M60/M62/M66 Simister Island – TR010064

Section 51 advice regarding draft application documents submitted by National Highways

The advice recorded in the table below relates solely to matters raised upon the Planning Inspectorate's review of the draft application documents listed above. The advice is limited by the maturity of the documentation provided by the Applicant and the time available for consideration and is raised without prejudice to the acceptance decision or the final decision about whether development consent should be granted.

FIGURE 2.2

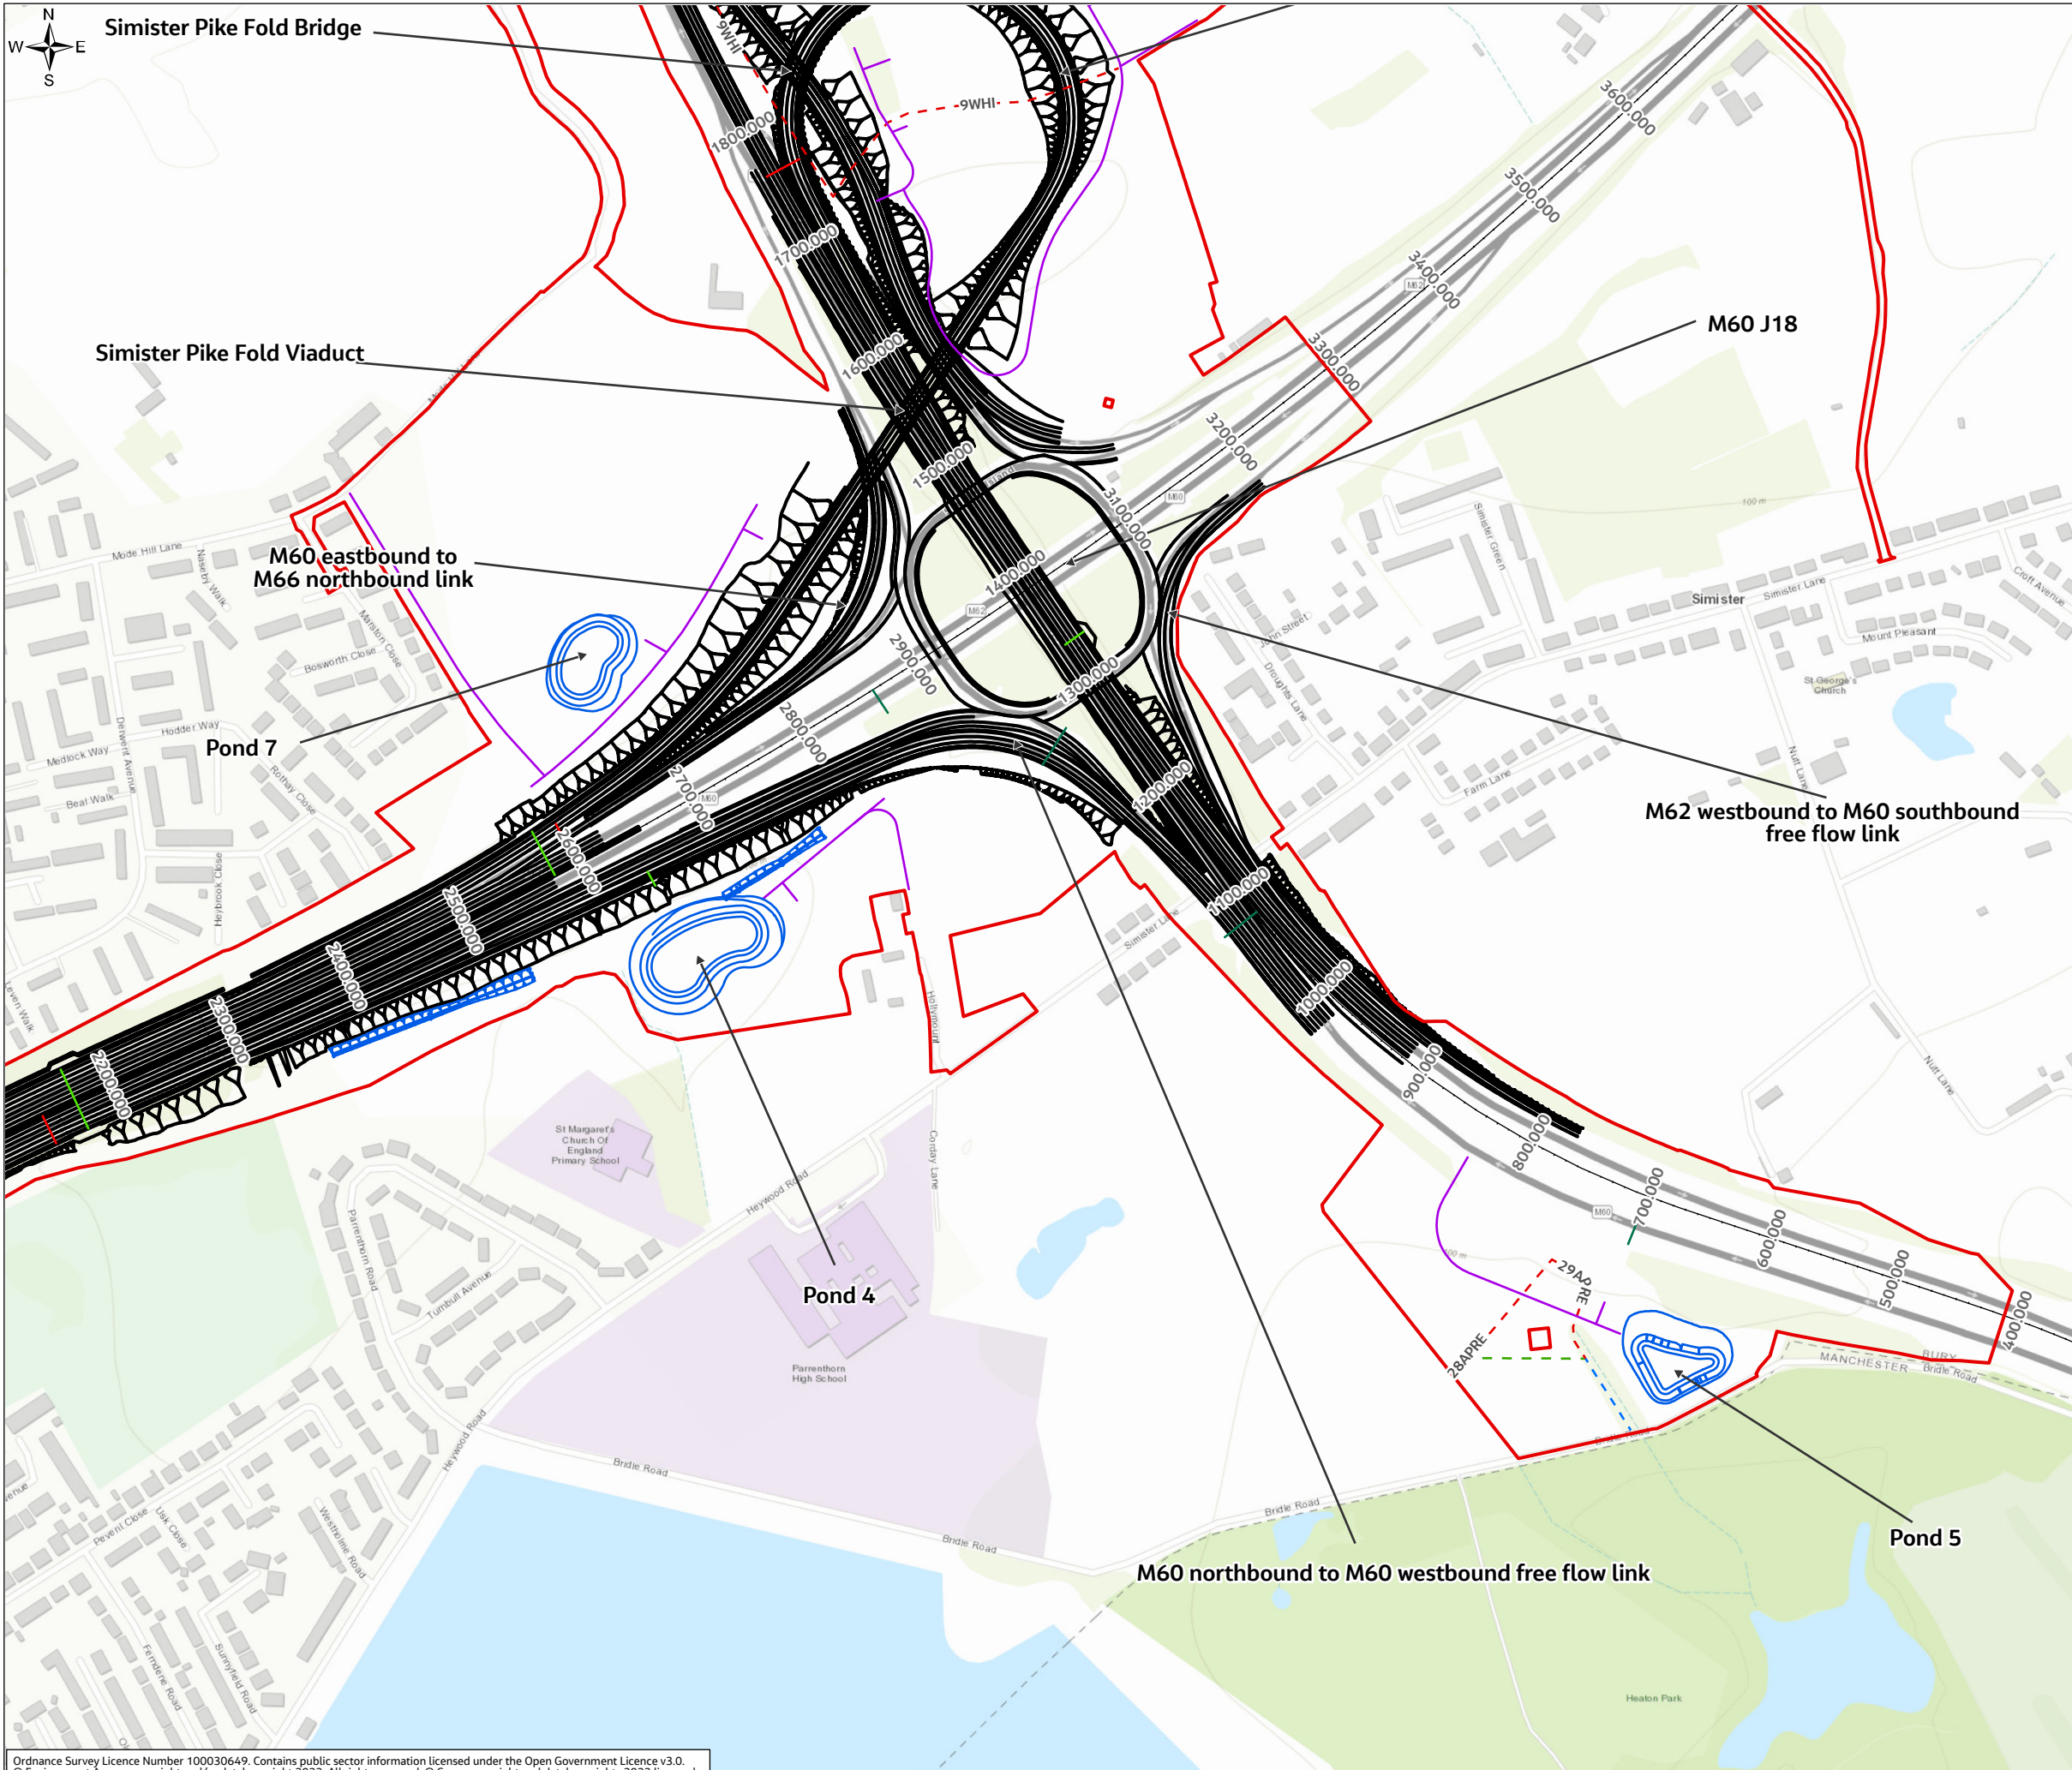
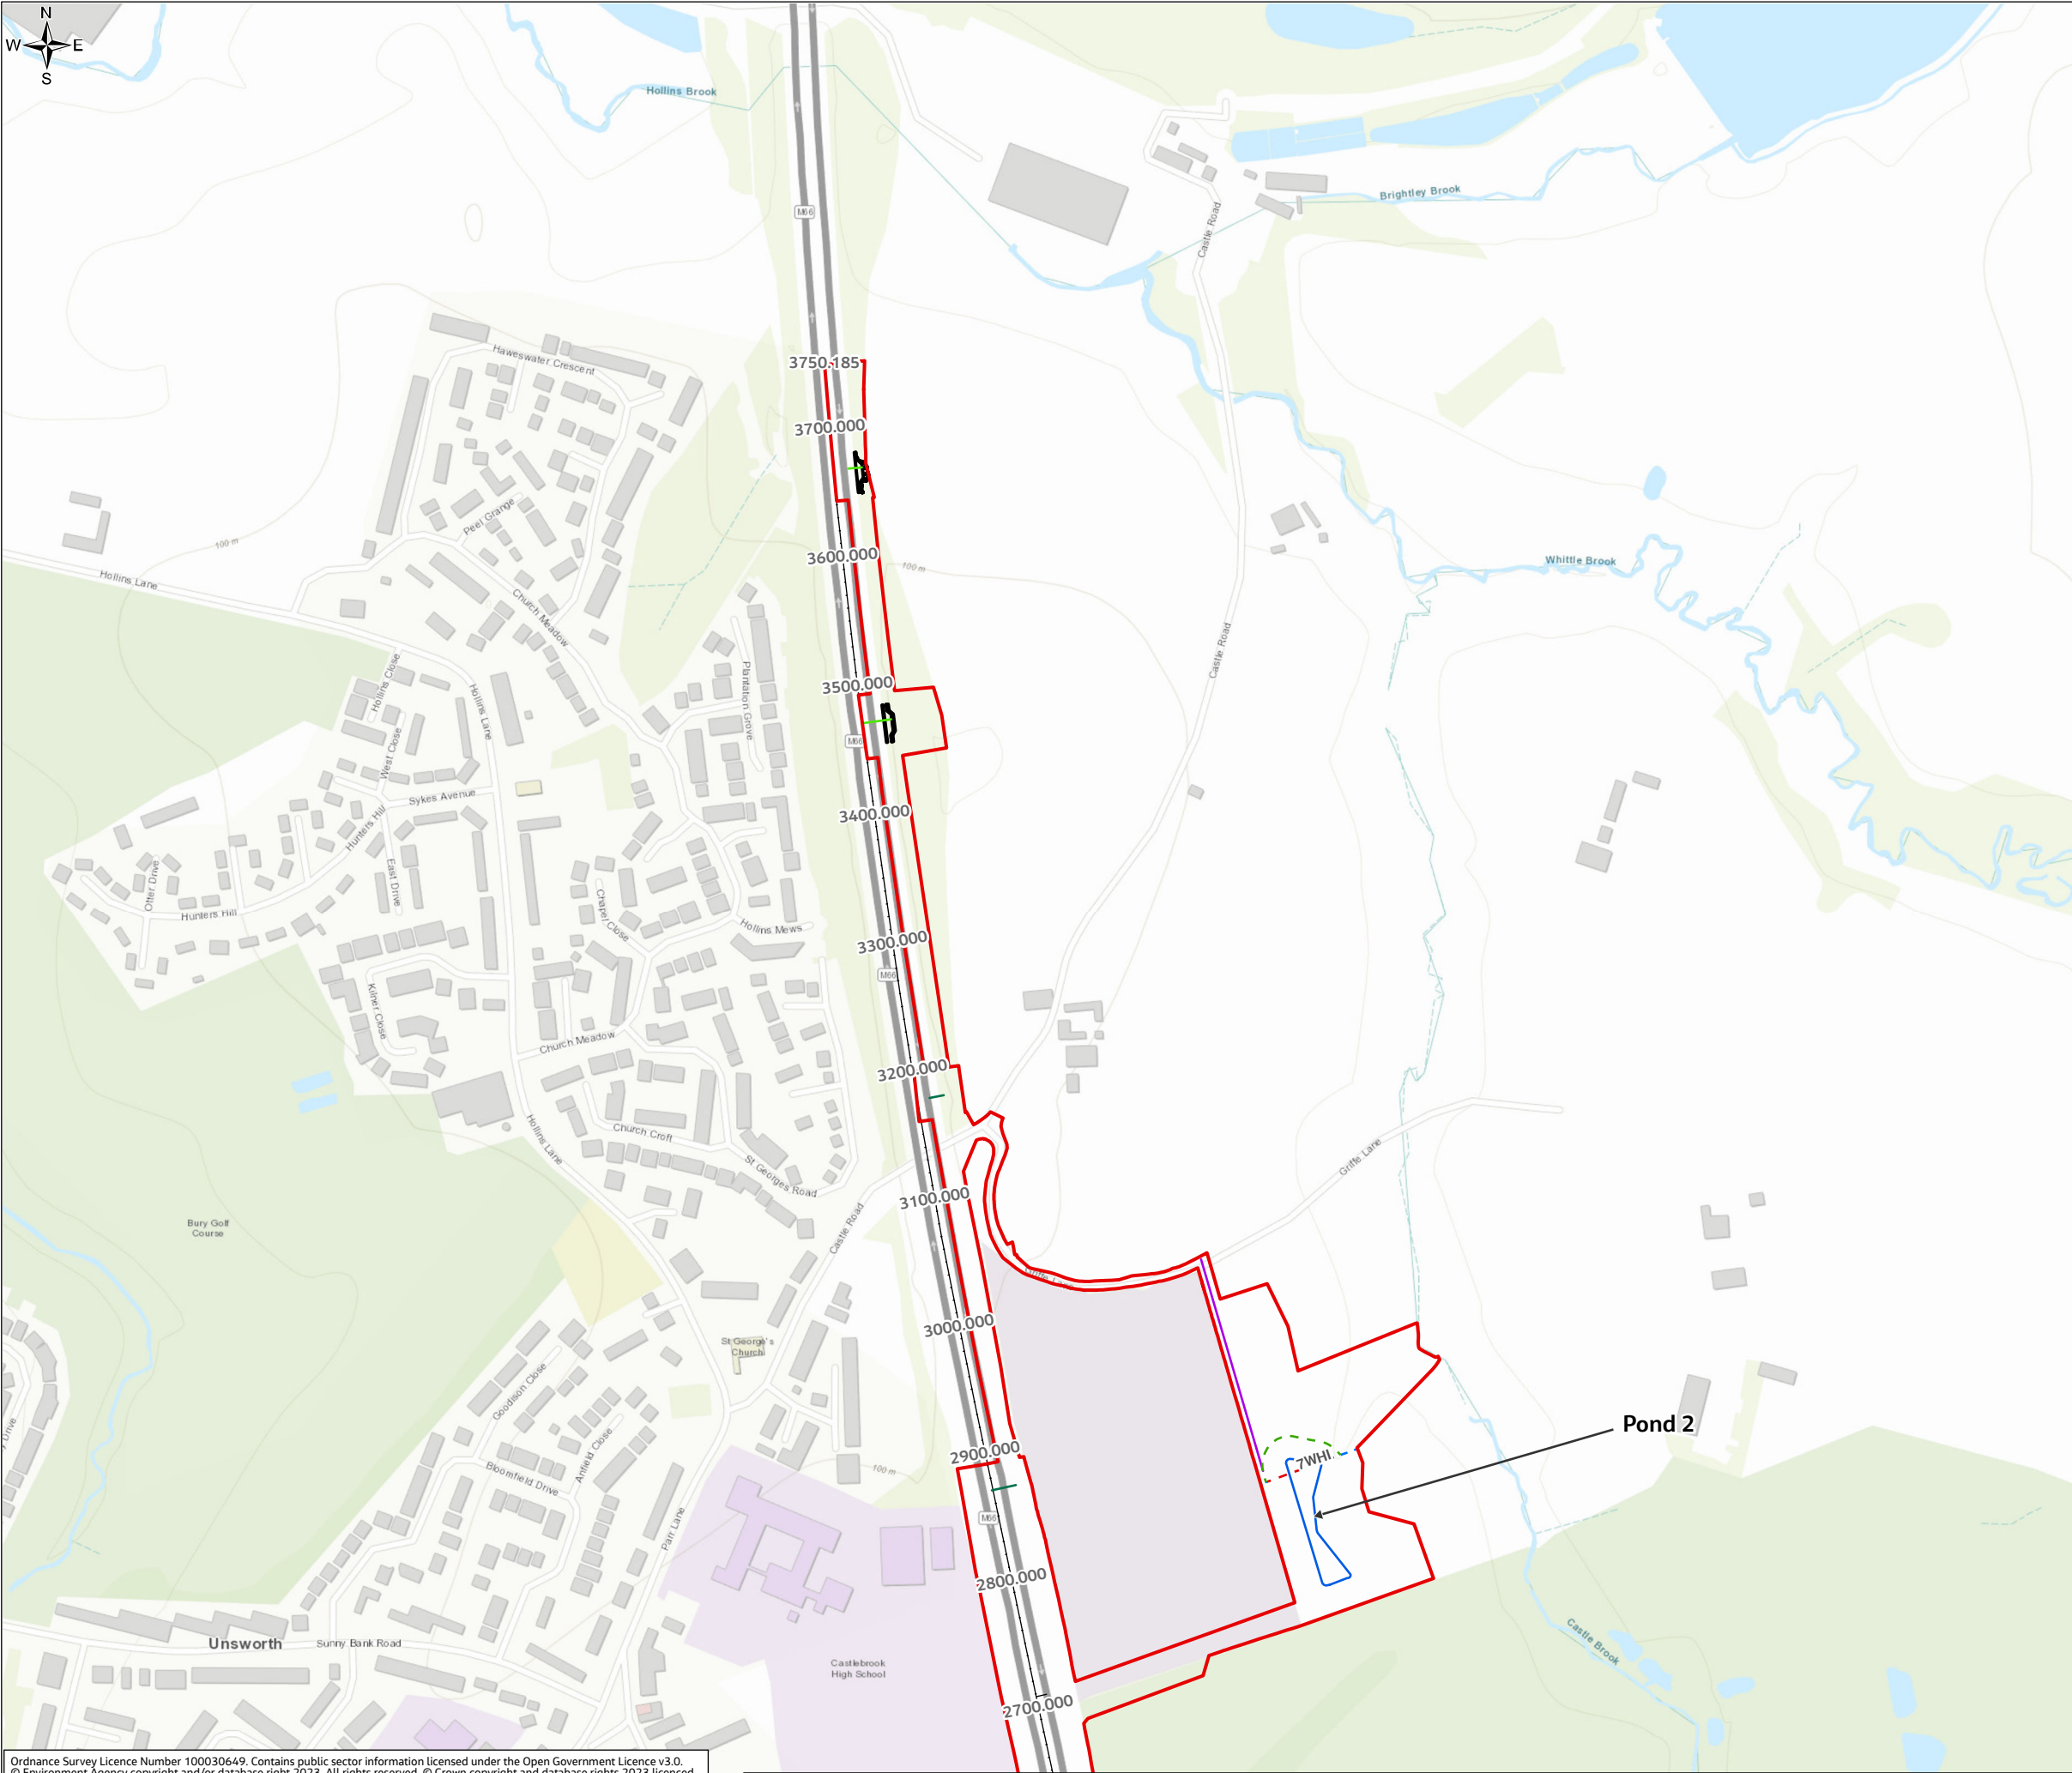
Environmental Statement Figure 2.2 Scheme design		
Ref No.	Paragraph/Section	Comment/Question
24.	ES Chapter 2, Table 2.1	ES Figure 2.2 does not depict the highway element/section 'M62 westbound to M60 southbound.' The Applicant should ensure that highway elements/sections match those described in ES Chapter 2 and ensure consistent referencing between documents.

Environmental Statement Figure 2.2 Scheme design		
Ref No.	Paragraph/Section	Comment/Question
25.	Figure 2.2	The Applicant should ensure that the arrows linking the label and the relevant element on the map align. The arrowheads for ponds 1, 2 and 5, as a basic example, do not correspond with the pond features.
